Reference No:	2025/62/91763/W
Site Address:	8, Giles Street, Netherthong, Holmfirth, HD9 3EF
Description:	Replacement windows, doors and front external wall (retrospective) (Listed Building within a Conservation Area)
Recommending Officer:	Joshua Merriman

DECISION - REFUSE

Officer Report – 2025/91763

Elevations as Existing

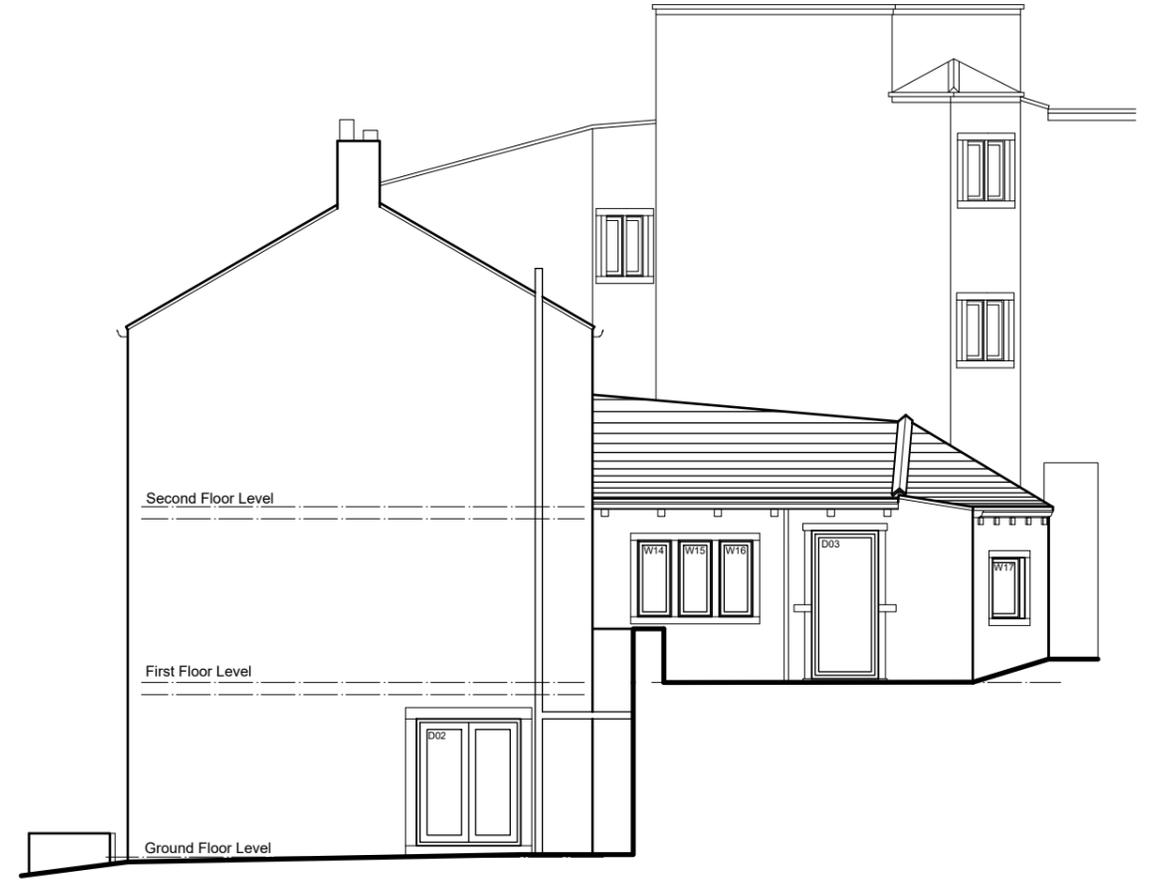
As the property is Grade II Listed and located within the Netherthong Conservation Area, it is considered that the dwelling must remain in keeping with the surrounding character, street scene, and the original appearance of the application property itself. The addition of uPVC windows and doors in place of the original timber windows and doors at the property is not considered to do this, as there are no examples of uPVC windows and doors in the immediate vicinity of the property, and the uPVC replacements do not follow the form, scale, layout, details, and character of the townscape, heritage assets, and landscape, as well as the street scene and locality. Considering this, and comments made by KC Conservation & Design, it is considered that the proposal has a significant impact upon the character and appearance of the Netherthong Conservation Area and a Grade II Listed Building and therefore cannot be supported.

1. The replacement windows and doors would fail to respect the original character and appearance of the Listed Building, and the features of architectural and historic interest which it possesses. The proposals would result in less than substantial harm to the significance of this Grade II Listed Building and to the Netherthong Conservation Area. Public benefits to outweigh such harm have not been demonstrated. The proposal is therefore contrary to Policies LP24 and LP35 of the Kirklees Local Plan, and policies within Chapters 12 and 16 of the National Planning Policy Framework.
